**Application by Tritax Symmetry (Hinckley) Limited for an Order Granting  
Development Consent for the Hinckley National Rail Freight Interchange – Deadline 7  
submission**

**Comments on Applicant's Deadline 6 submission**

**LCC response to information requested by the ExA – Detailed comments on the draft Planning Obligation**

**M69 J2 SOUTHERN BRIDGE STRUCTURE EXTENTS**

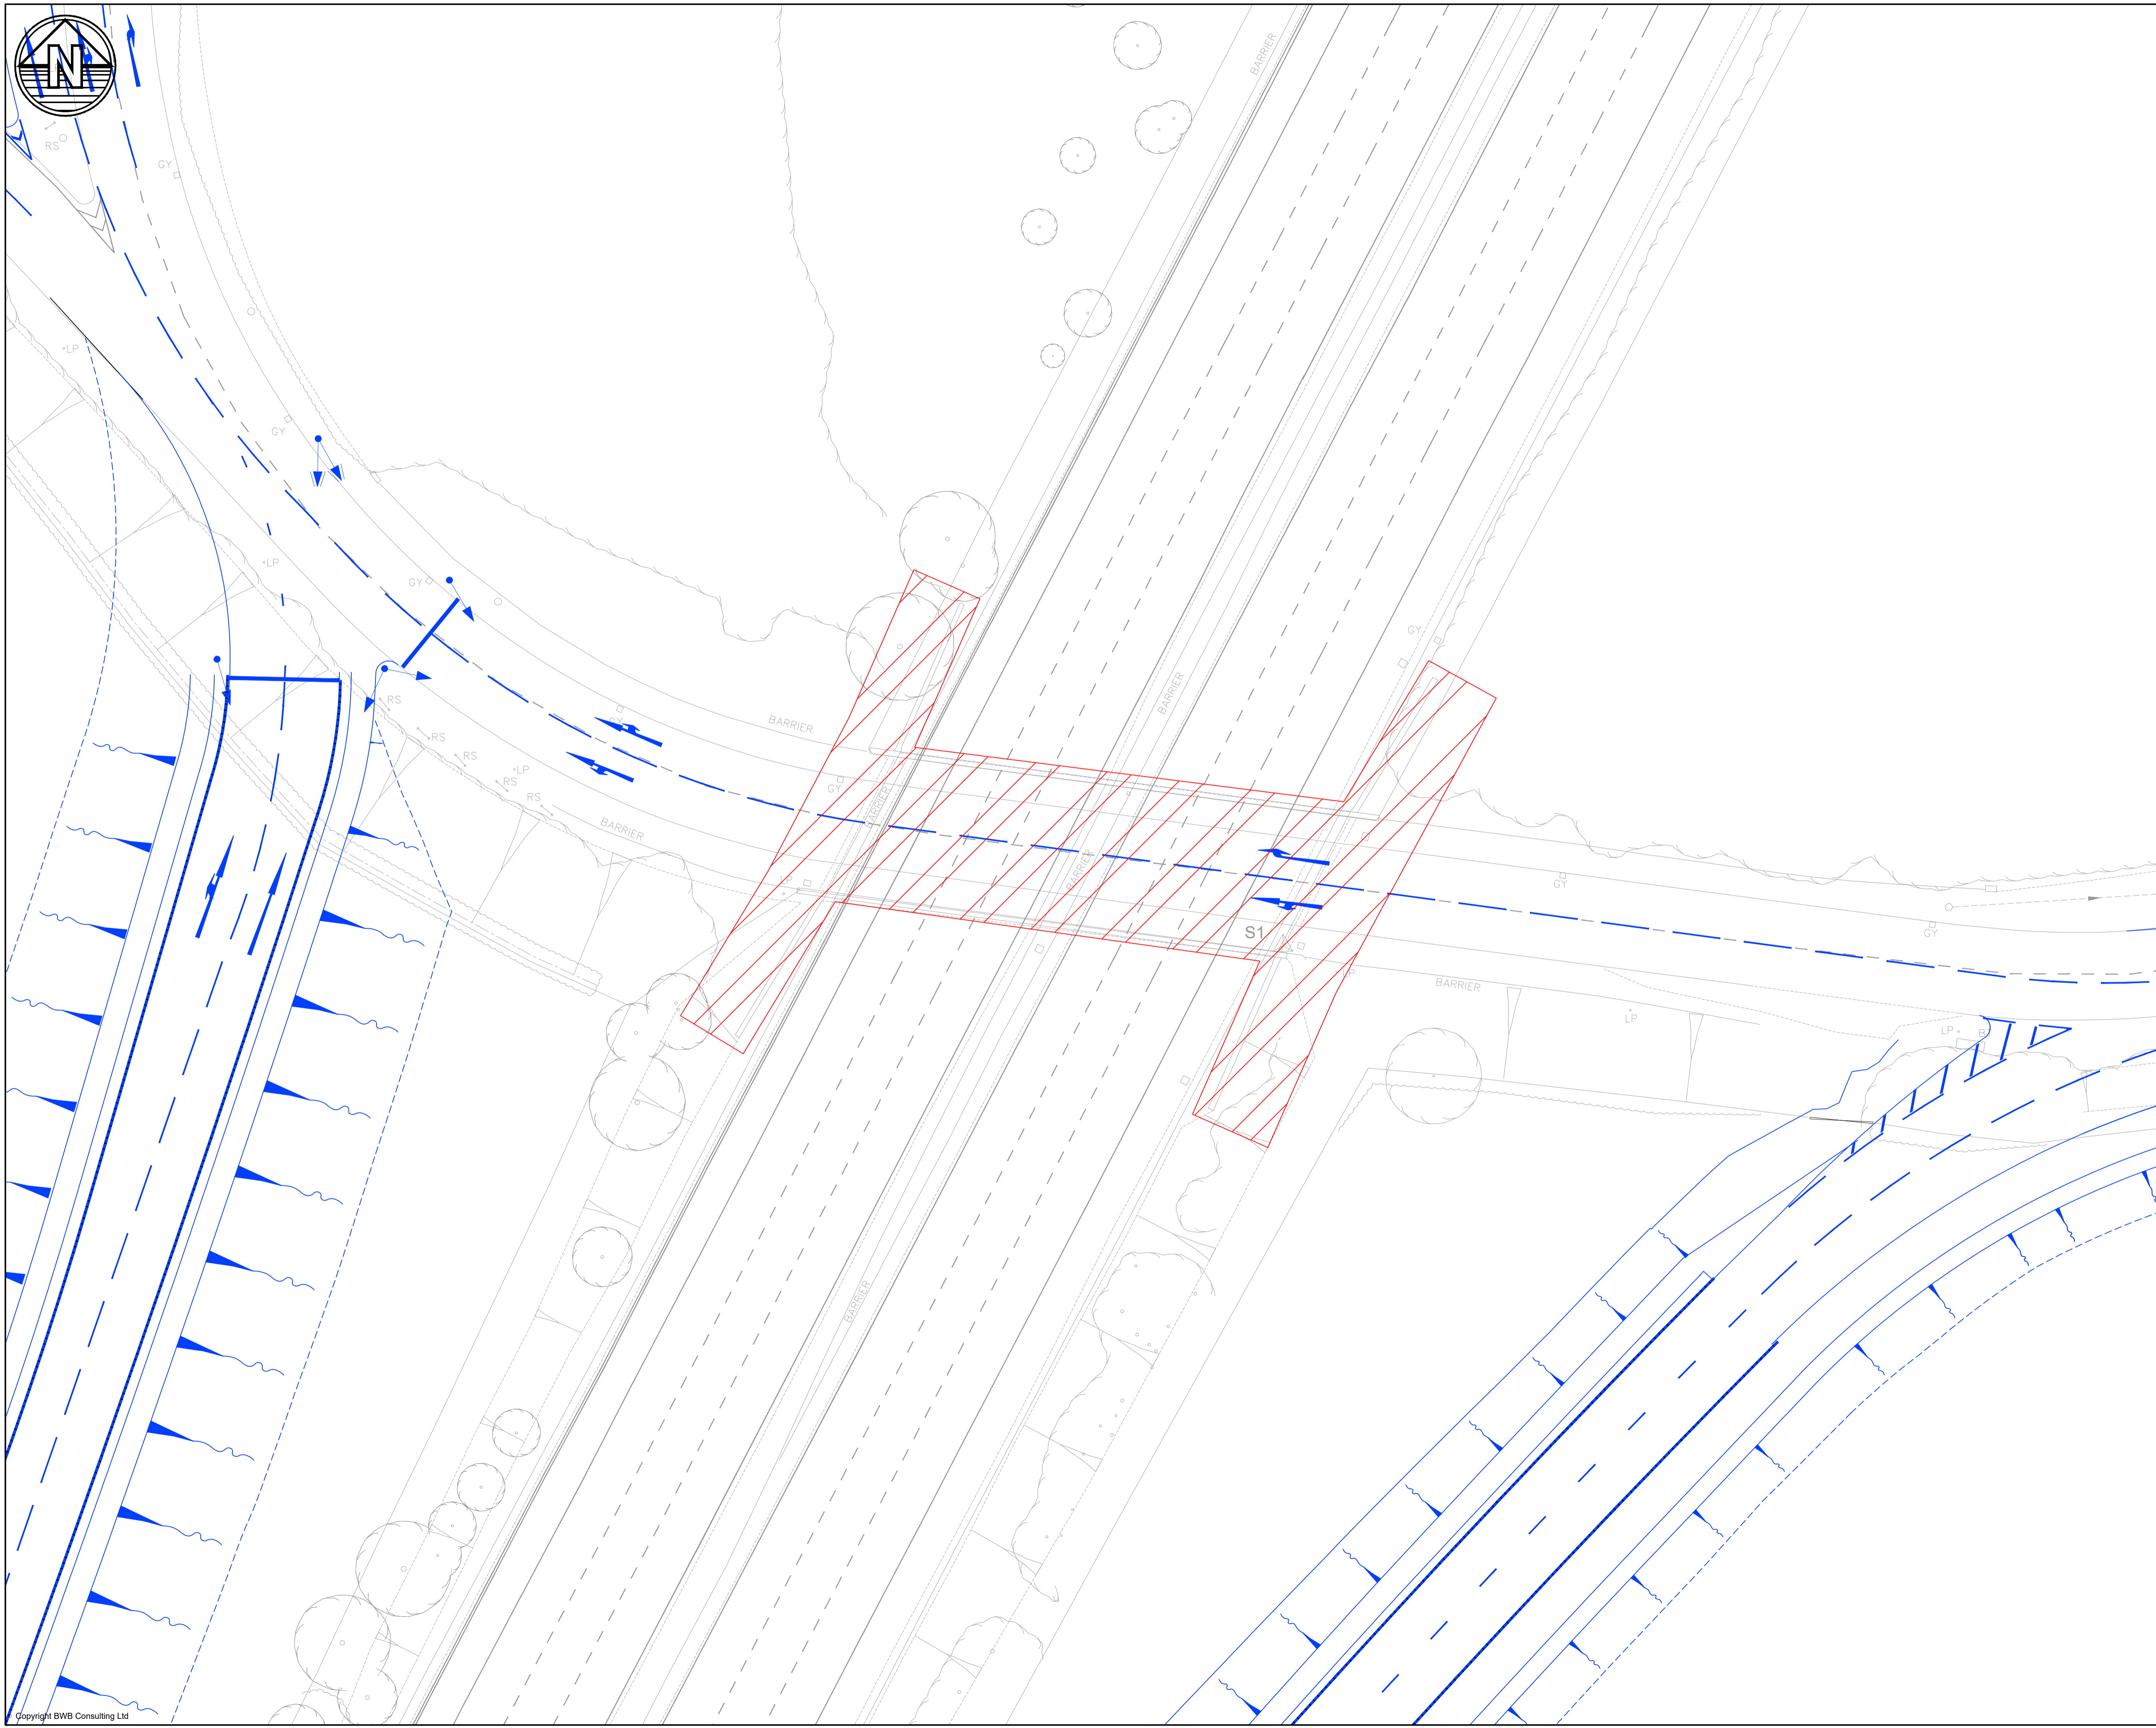
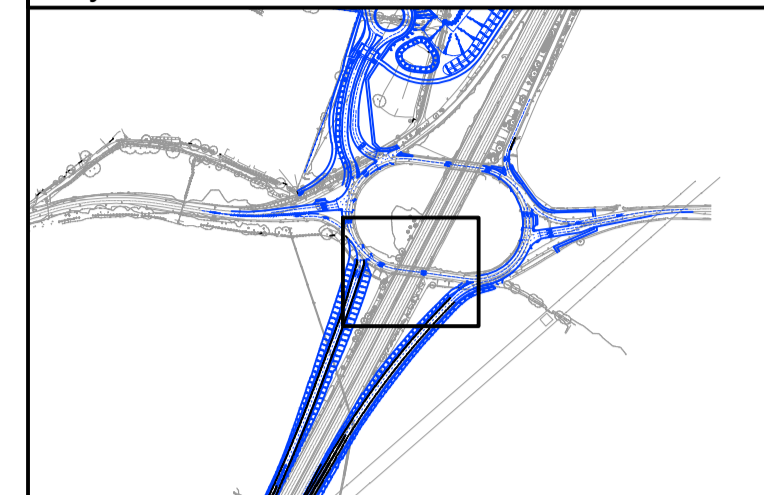
<b>Examination library reference</b>	<b>Document name</b>	<b>Leicestershire County Council comments</b>
REP6-003	2.31.1 M69 Junction 2 Existing Structures Overlaid on Proposed Works	LCC welcome the submission of a drawing to demonstrate that the addition of south facing slip roads can be accommodated without impacting on the existing M69 J2 structures.
REP6-006 REP6-007	6.2.8.1D Hinckley NRFI ES Appendix 8.1 Transport Assessment - part 15 of 20 - Sustainable Transport Strategy and Plan and Appendices	LCC note that the only updates to this document appear to be references to travel packs, and a DRT app. None of the concerns raised by LCC in its written representations at various Deadlines to date appear to have been addressed.
REP6-012	17.1B Hinckley NRFI Construction Environmental Management Plan	LCC note that this plan has not been updated to reflect the construction of a ramped footbridge at The Outwoods level crossing. It is unclear if this will impact on buildability, access etc.
